**Application for a non-material amendment following a grant of planning permission,
Town and Country Planning Act 1990**

**Non material amendment to previous permission 2019/91657 for erection of 30
dwellings**

Land at Station Road, Skelmanthorpe, Huddersfield, HD8 9BA

Application Number: 2023/90743

HOUSE TYPE B
1902-HT-B-01B
STATION ROAD, SKELMANTHORPE
YORKSHIRE COUNTRY PROPERTIES
SCALE:1:100@A3 - MAY 2019
PARKER PEEL
ARCHITECTURAL
e jp@parkerpeel.co.uk w www.parkerpeel.co.uk t01924 921 860

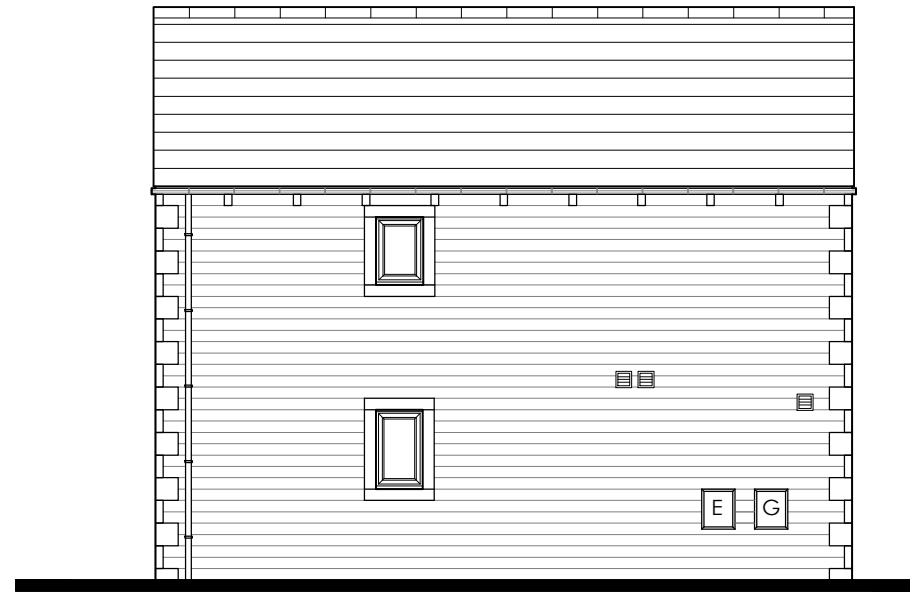
- B Type (Plot 13-15) Side lights removed from French doors on rear elevation.
- C1 Type (Plot 12) Additional side window added to bedroom 2.
- C2 Type (Plot 8) Window added to Plot 8 bathroom only.
- G Type (Plot 29) Single story rear extension added to provide additional kitchen space and utility room added.
- J type (Plot 30) Rear window removed from bedroom 2.
- K Type (Plot 25) Minor adjustments to overall build to suit construction purposes.
- L Type (Plot 24) Parapet walls introduced at roof level.
- M Type (Plot 23) Room above garage removed, other amendments including repositioned windows.
- N Type (Plot 26) Side door to utility added and double window to the dining room replaced with a triple window.

I confirm that the amendments are acceptable and may be considered as a non-material amendment to the approved drawings. It should be noted that this letter relates only to the non-material amendment sought and it is not a re-issue of the original planning permission. The two documents should be read together and as such, all conditions imposed on the original granting of planning permission apply to the proposal as now amended. A copy of this letter and the amended plans will be retained on the public record of approved documents.

HOUSE TYPE C1
1902-HT-C1-01B
STATION ROAD, SKELMANTHORPE
YORKSHIRE COUNTRY PROPERTIES
SCALE:1:100@A3 - MAY 2019

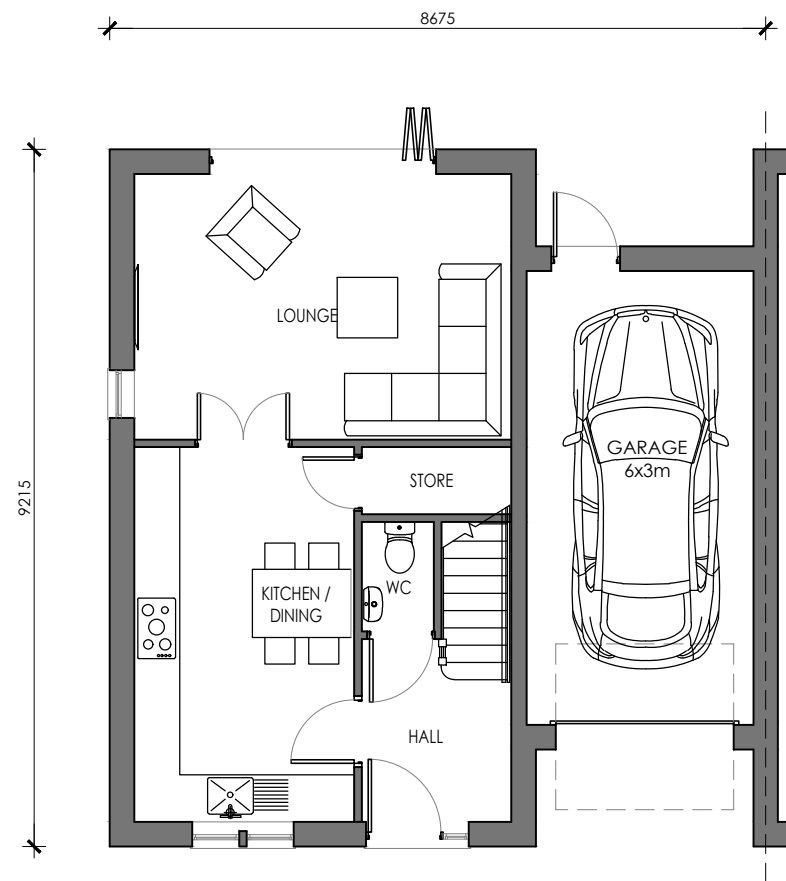
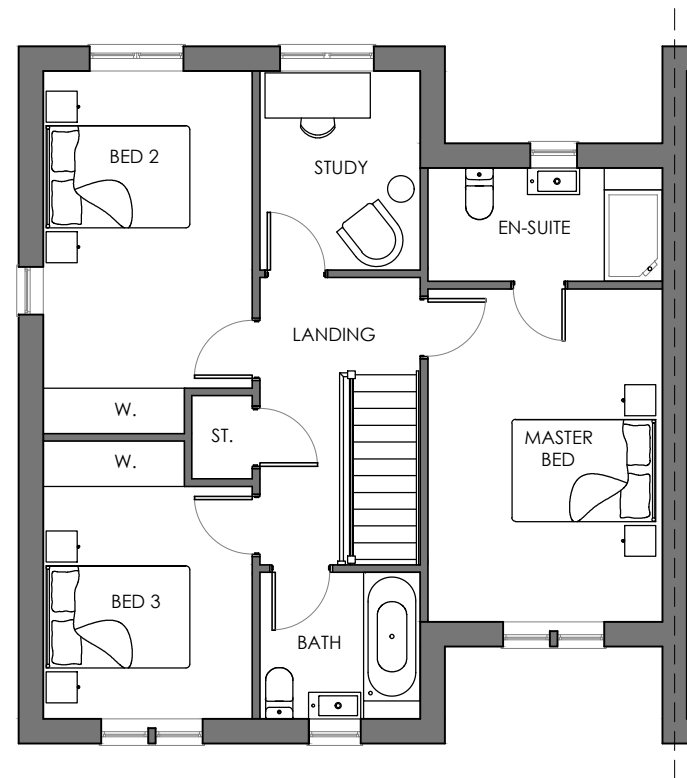
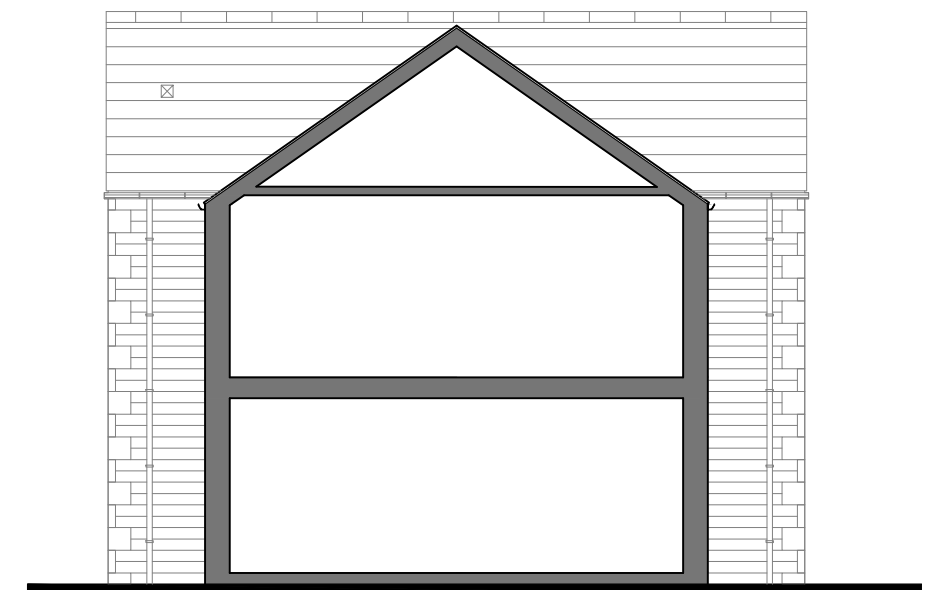
- C1 (plot 12) ground floor side window moved.
- G (plot 29) changes to footprint dimensions (8383mm x 6860mm previously approved, 8495mm x 6852mm now proposed).
- The relief in G's front and rear elevations also appears to have been deleted (resulting in dwelling having a single roofline), although this isn't reflected in the Site Layout Plan (rev K).
- L (plot 24) front ground floor projections slightly reduced in size.
- Unit 23 moved slightly southwestwards towards site boundary.
- Unit 24's garage moved slightly southeastwards towards trees.
- Unit 25's garage moved slightly northeastwards towards site boundary.
- Garden layout changes.
- Meters, burglar alarm boxes, vents and external light fittings shown to external elevations.
